RE: **9841 Buckeye St. NW**
Grading Plan
Engineer's Stamp Date 11/20/17
Hydrology File: B13D028

Based on the information provided in your submittal received 11/21/17, the Grading Plan cannot be approved for Building Permit until the following are addressed:

**9841 BUCKEYE STREET, NW  
GRADING PLAN**

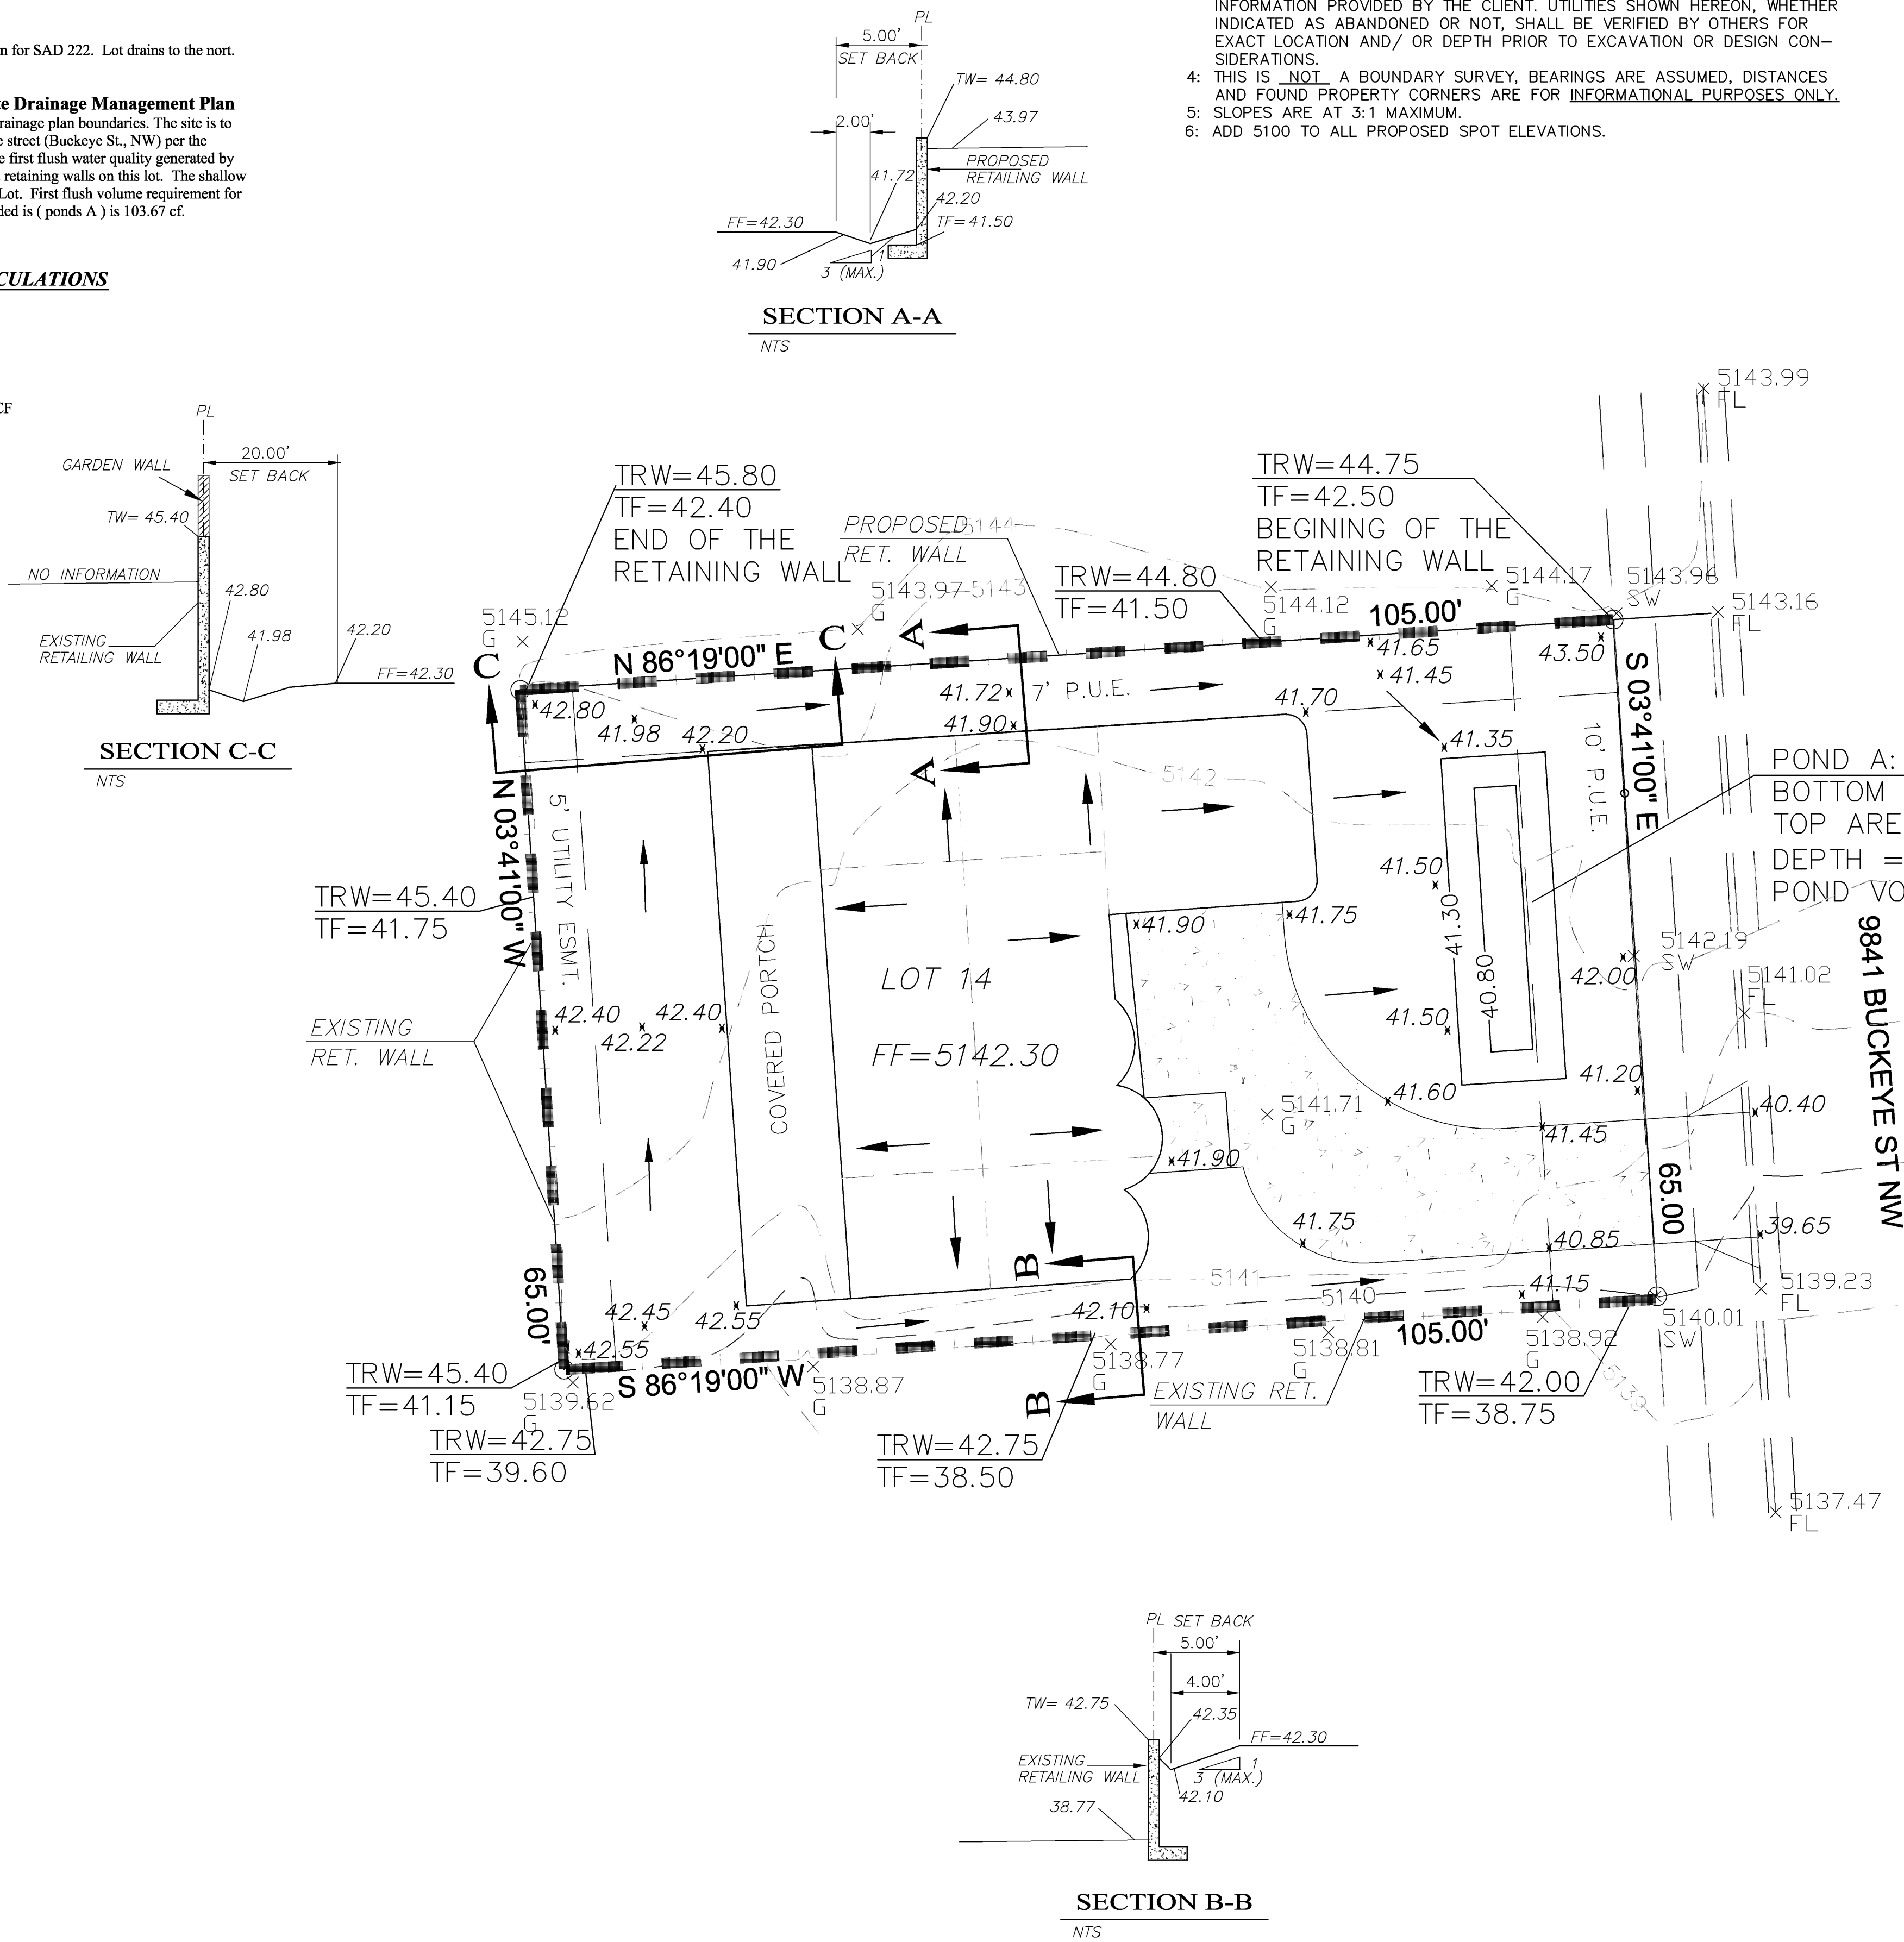
1. Provide section cuts of the proposed retaining wall and the two existing retaining walls. Ensure these section views show that the flowline is not set against any retaining walls or walls of the house.
2. Show the property line, existing and proposed grades on the section views. In accordance with Ch.22, section 5 part B, of the DPM, grading and wall construction near the property line may not endanger adjacent property or constrain its use.
3. If the proposed retaining wall will create such an encroachment, written agreement from both landowners must be provided for such work.
